Case Officer: Gemma Magnuson

Applicant: Ms Debbie Whitford

Proposal: Removal of roof. Construction of new roof with bedroom accommodation

Client **MS DEBBIE WHITFORD**  
 Drawing **PROPOSED PLANS AND ELEVATIONS**  
 Date **September 2019** Drawing no **2019-20/12/2**  
 Scales **1:50 @ A1**

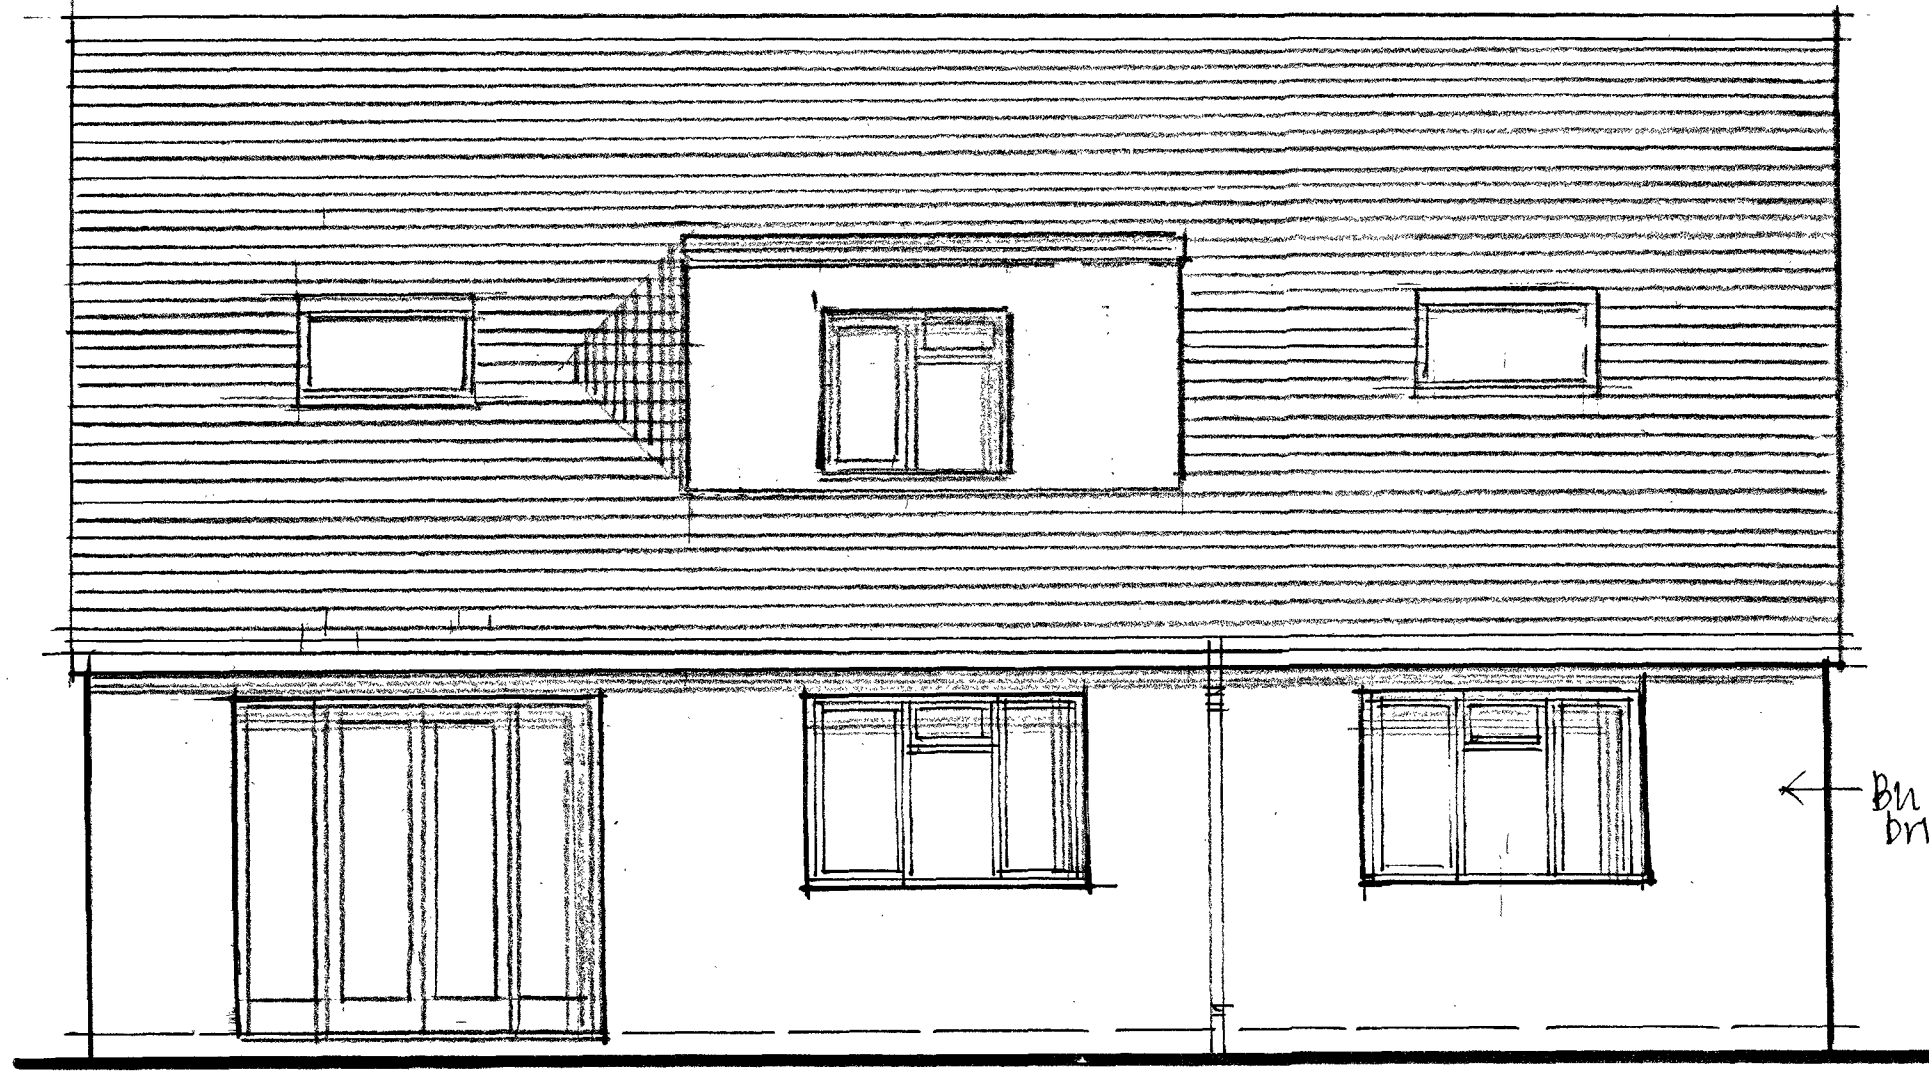
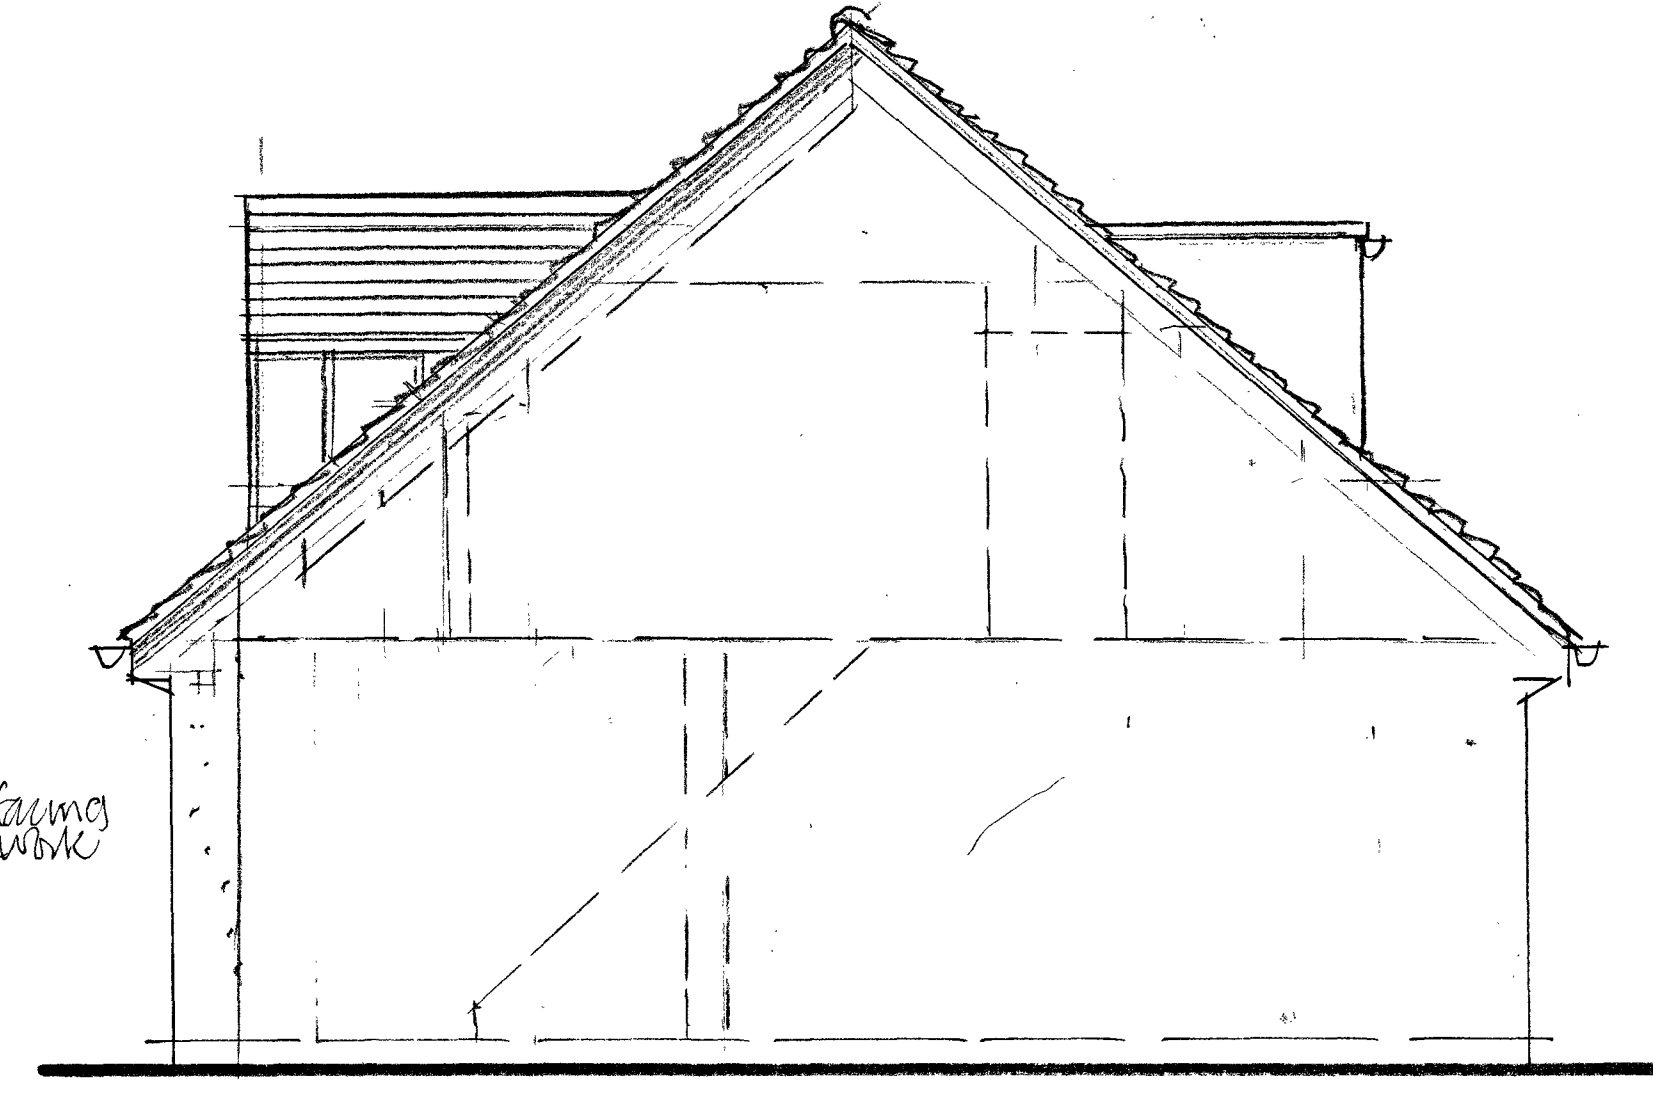
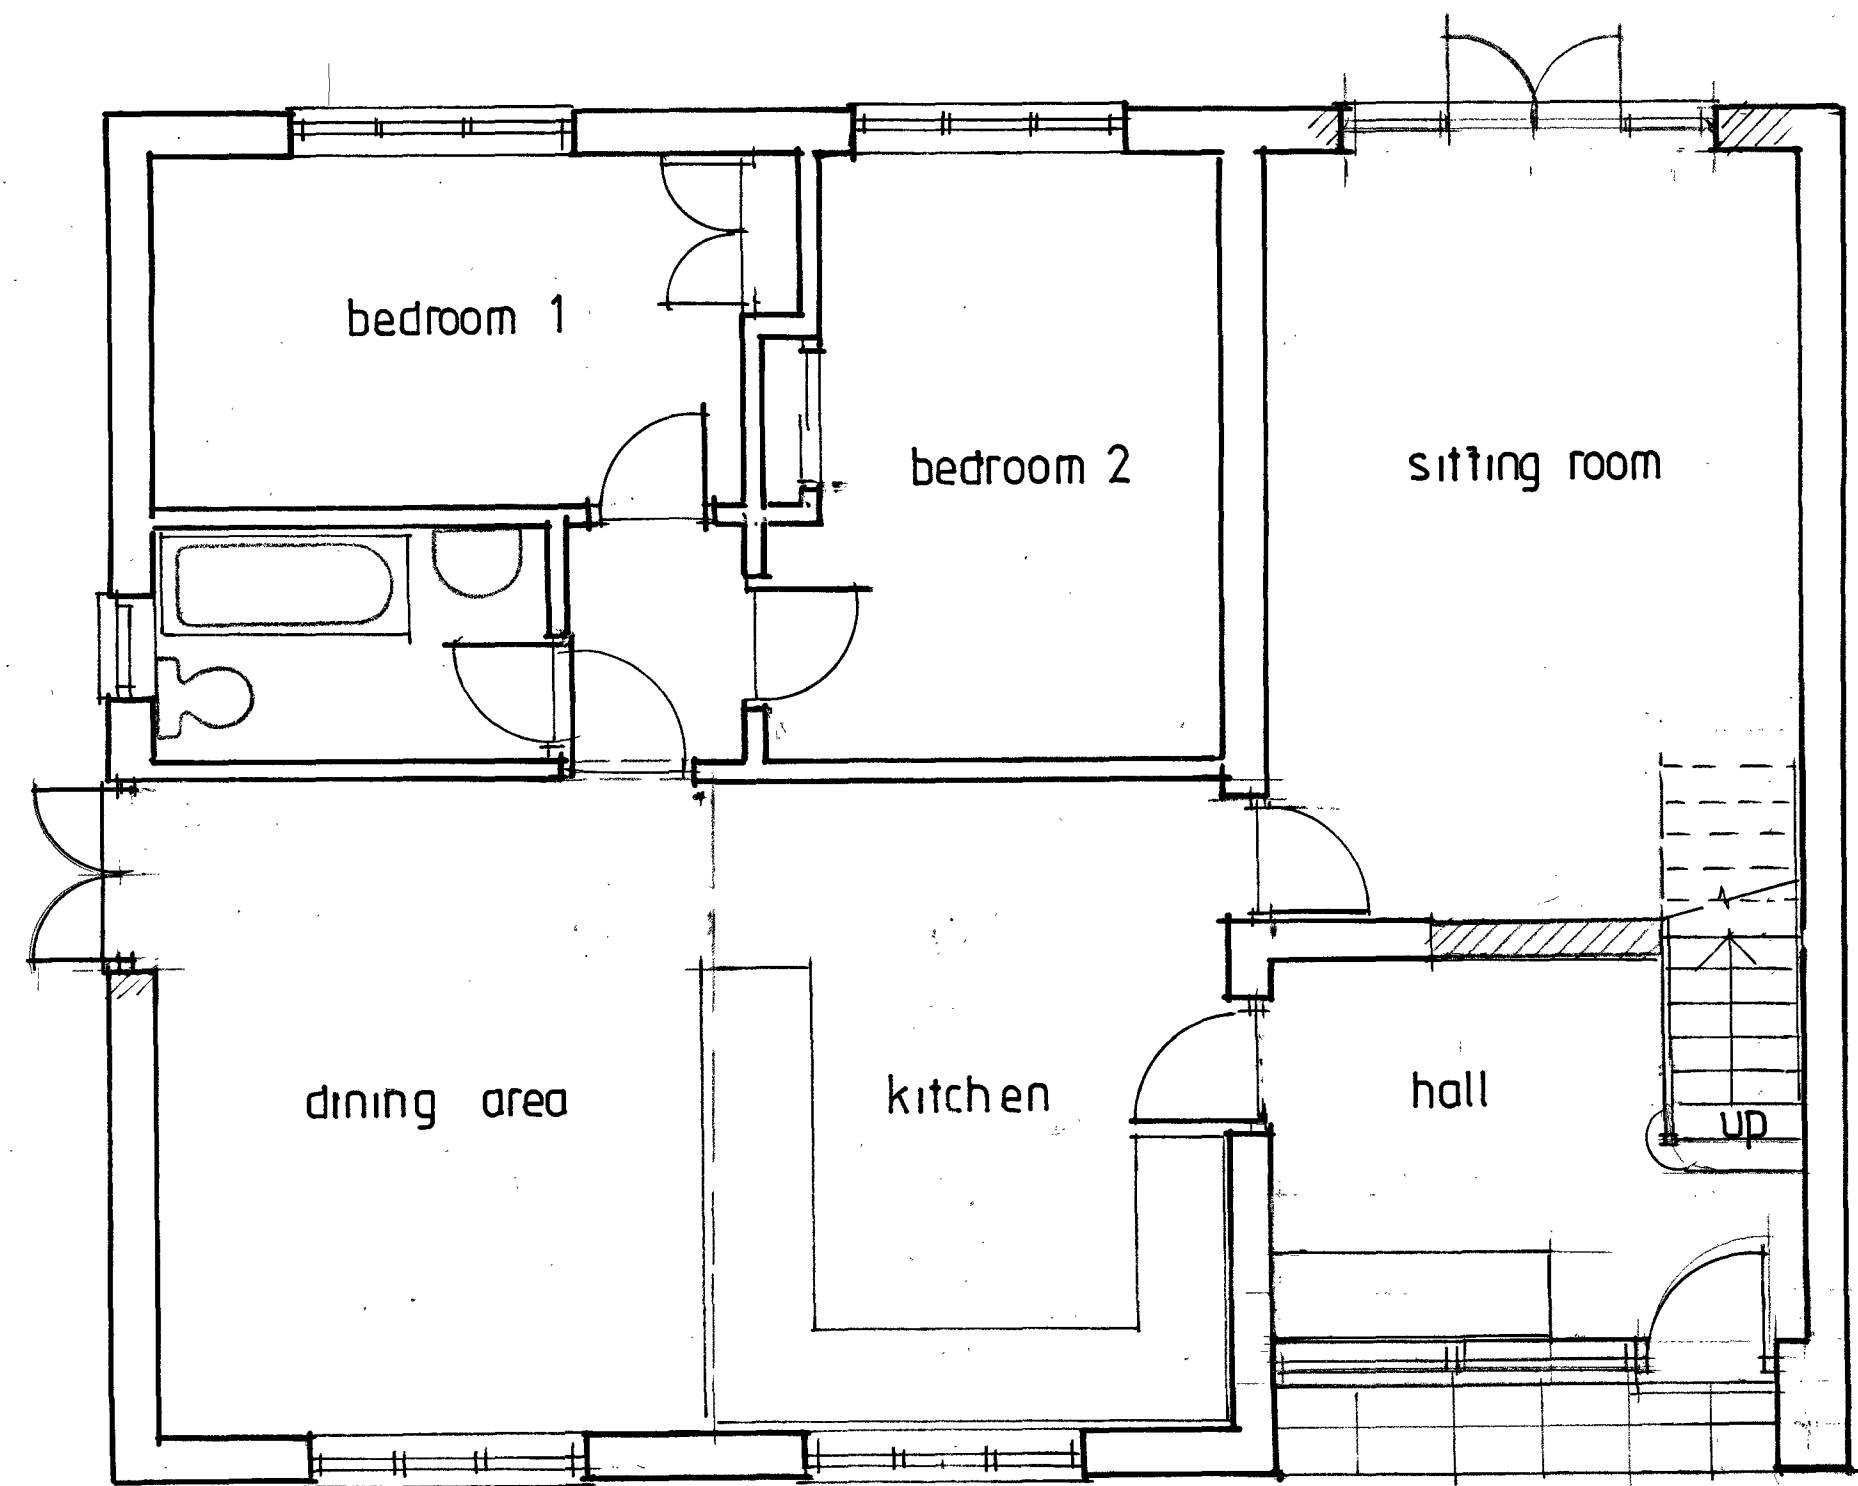
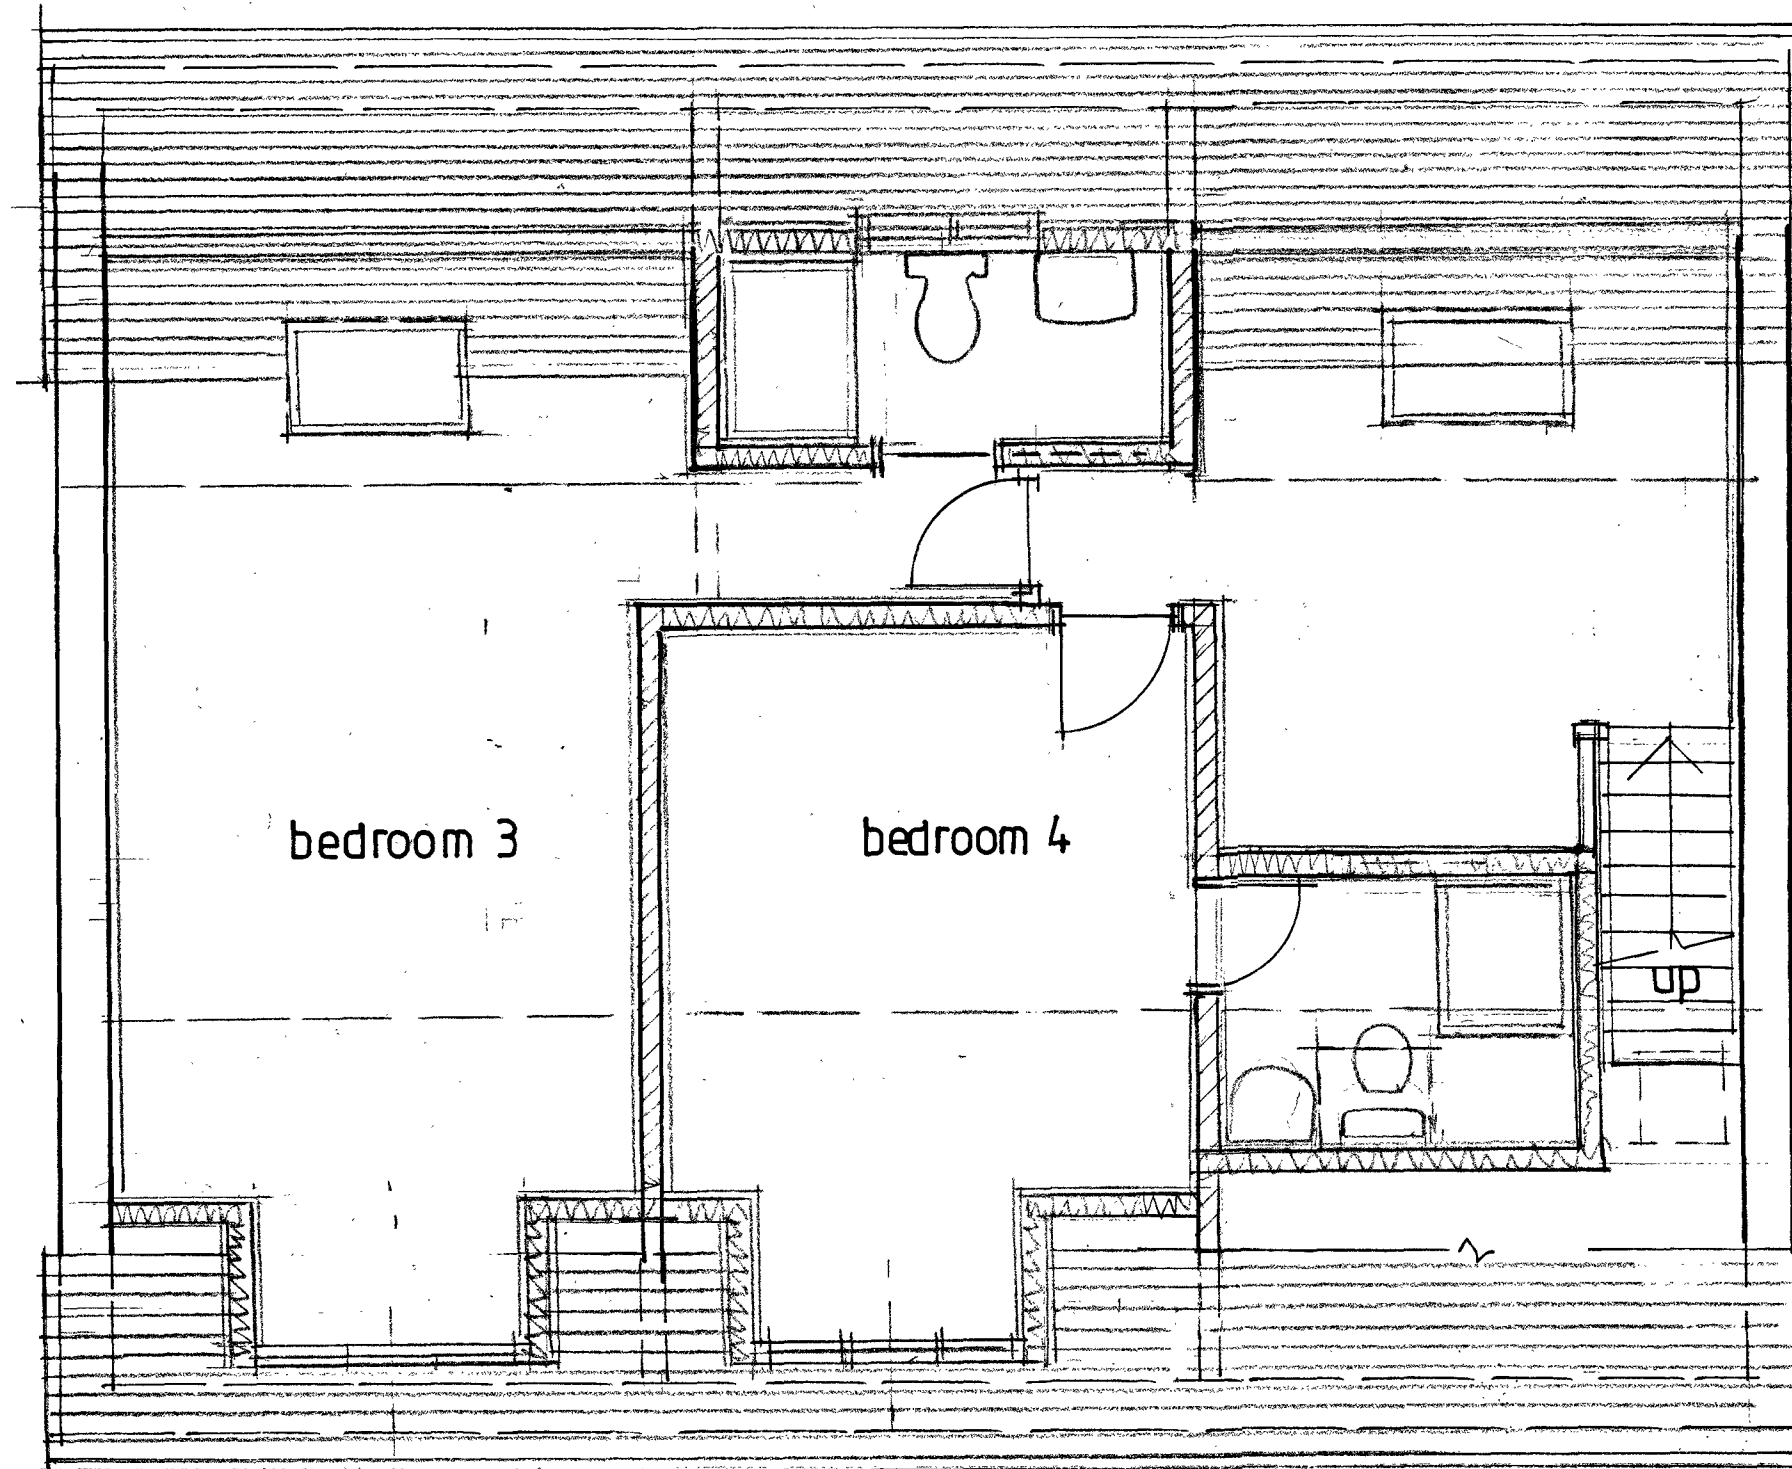
- 8.8. Pitched roofed dormer windows are proposed upon the more visibly prominent frontage, and I consider these to be sympathetically designed, centred over the ground floor openings and not appearing disproportionate to the remaining roofslope.

- 8.9. A flat roofed dormer window is proposed to the rear, which in unfortunate, as it would be visible from the adjacent car park. However, given its small size, I do not consider that it would appear overly prominent or cause harm. The rooflights are not excessive in number, and I do not consider that they would cause harm.

- 8.15. Firstly, The Old Seven Stars to the south-west of the site. Whilst the proposed increase in height and openings would be a sufficient distance from the dwelling itself to avoid harm, the proposed flat roofed dormer window would be positioned in close proximity to the shared boundary to the west, and would be visible above the existing boundary hedge where there are no openings at present.

- 8.16. However, given the small size of the dormer, the proposed use of obscure glazing and that not the entirety of this neighbour's garden would be affected by the perception of overlooking, I do not consider that I can reasonably argue that significant harm would be caused in terms of a loss of privacy for this neighbour. I have recommended that all openings on this elevation are obscure glazed in order to avoid any overlooking of the neighbour, with any opening parts above 1.7 metres from floor level.

4. The rooflights and bathroom window on the western facing elevation shall be obscure glazed (Level 3 or above) and fixed shut, unless the cill height of any opening parts are 1.7 metres above the floor of the room within which it is installed.

6. Notwithstanding the provisions of Classes A, B and C of Part 1, Schedule 2 of the Town and Country Planning (General Permitted Development) (England) Order 2015 and its subsequent amendments, no new window(s) or other openings, other than those shown on the approved plans, shall be inserted in the roof of the western facing elevation without the prior express planning consent of the Local Planning Authority.
